Project No: 301351072

3-5 Help Street, Chatswood

**RE: 3-5 Help Street Chatswood  
RtS Response**

ON-SITE DETENTION TANK - PLAN

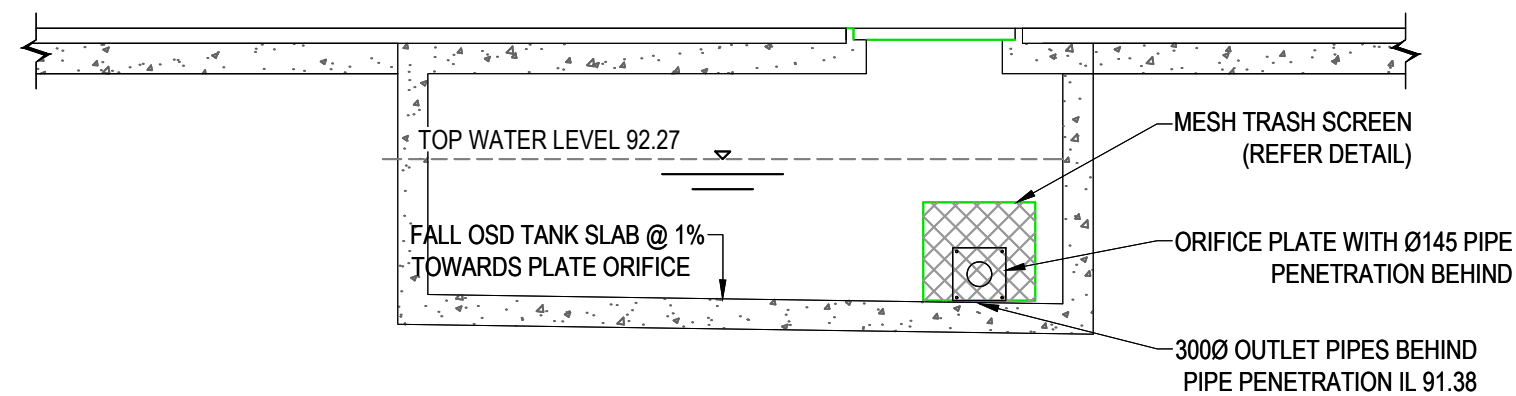
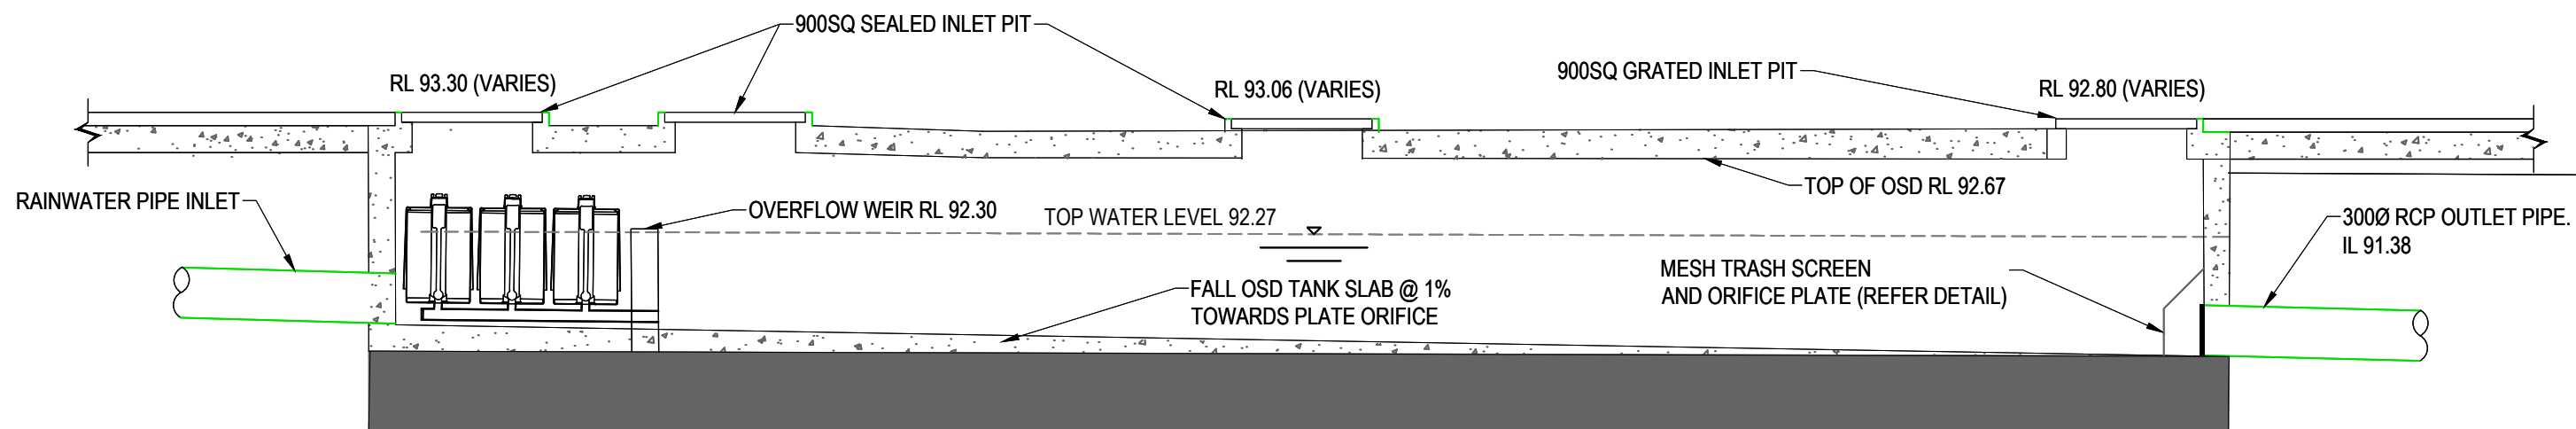
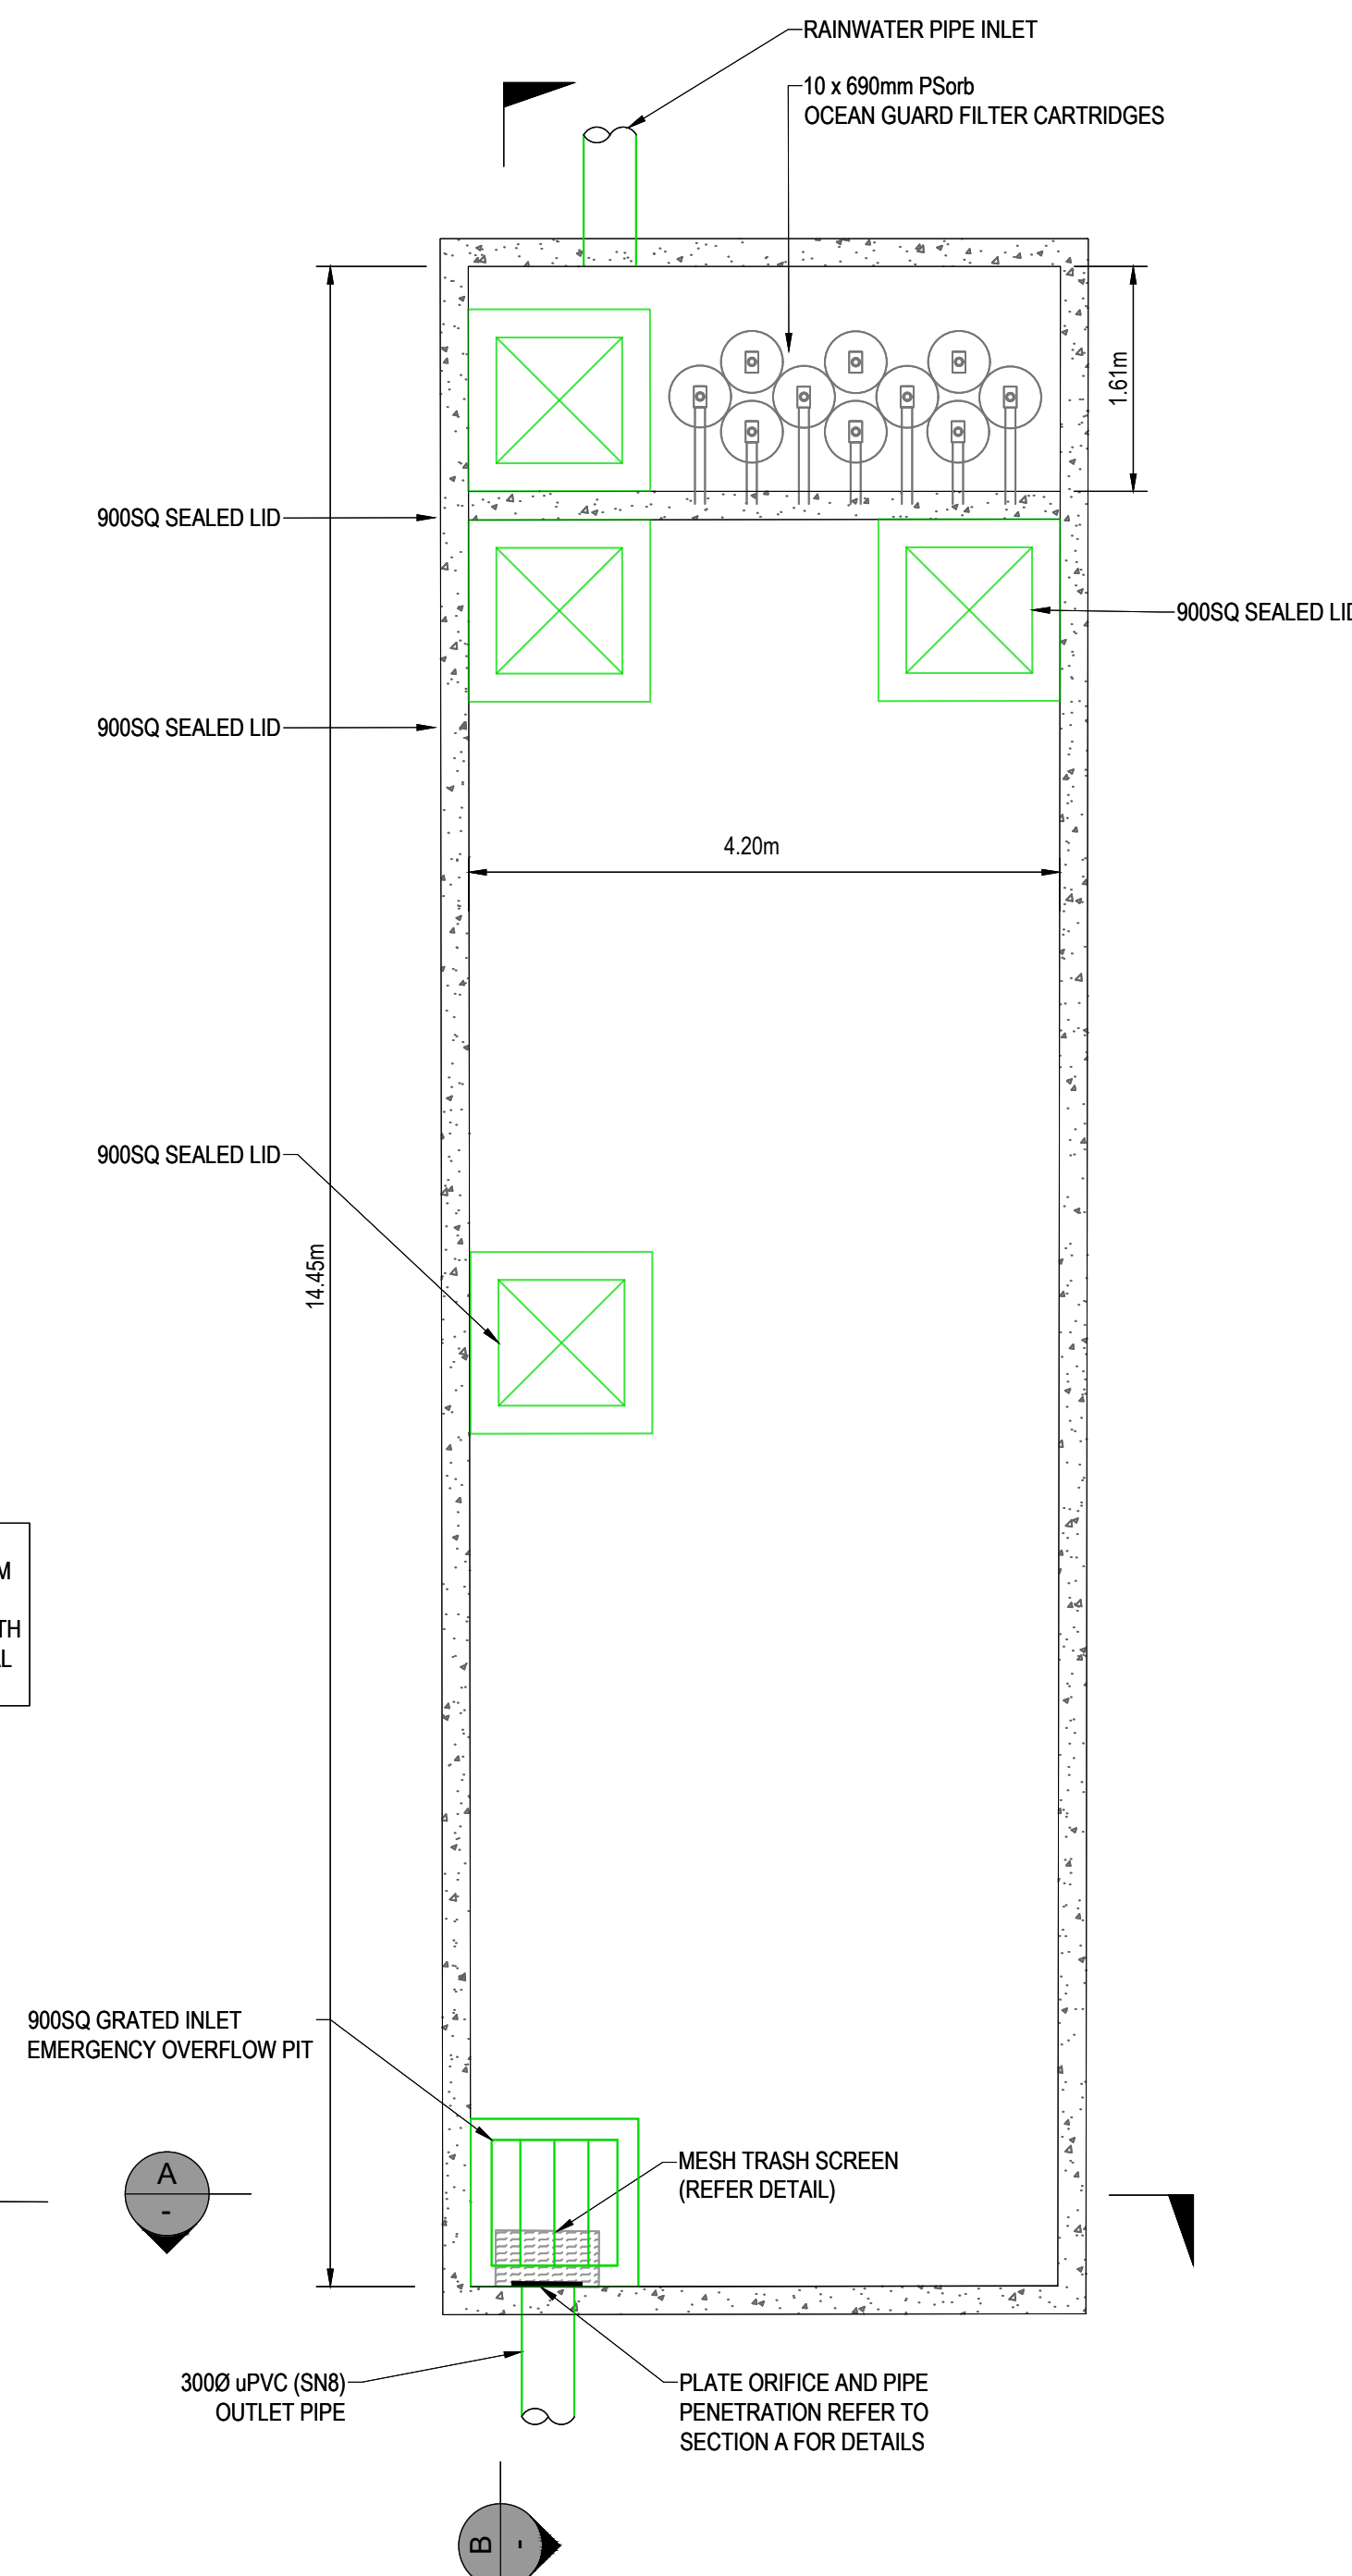
*The stormwater management system includes an OSD system, as required by Part I of the DCP and Technical Standard 1. However, the system proposed does not reduce peak flows to meet Council's permitted site discharge (PSD) requirements. The proposed system limits peak flows from the site in the 1%AEP storm to 65L/s and not the 39L/s required to comply with Council's requirements. The documentation has provided the analysis of the 1%AEP water level immediately downstream of the OSD tank. The analysis has detailed that the 1%AEP water level at the OSD tank is RL 91.46m, while the base level of the OSD tank is RL 91.38m. Council requires that the base level of the tank is above the 1%AEP water level, so that the downstream water level does not impact the operation of the OSD system and that the required PSD can be achieved. To achieve this requirement, the base of the tank needs to be raised to RL 91.45m. Details have not been provided to confirm that floor levels in the building immediately adjacent to the tank are a minimum of 300mm above the overflow grates in the top of the tank. However, we believe that this is achieved. Stormwater quality improvement measures are proposed and details have been provided to confirm that the measures comply with the requirements of Part I of the DCP and Technical Standard 1..*

The Civil Engineering Documentation and design has been updated to increase the OSD tank volume to a maximum 111m<sup>3</sup> storage, with a base of tank RL of 91.45m. Due to the area of bypass that is unable to be captured by the stormwater management system along the Help Street frontage, the OSD has been required to store and release runoff to a maximum of 14L/s in the 1% AEP storm event. With 25L/s being discharged from the Help Street frontage bypass, the total permissible site discharge from the site is 39L/s. A DRAINS model has been prepared with updated levels, tank storage and tank orifice plate demonstrating this.
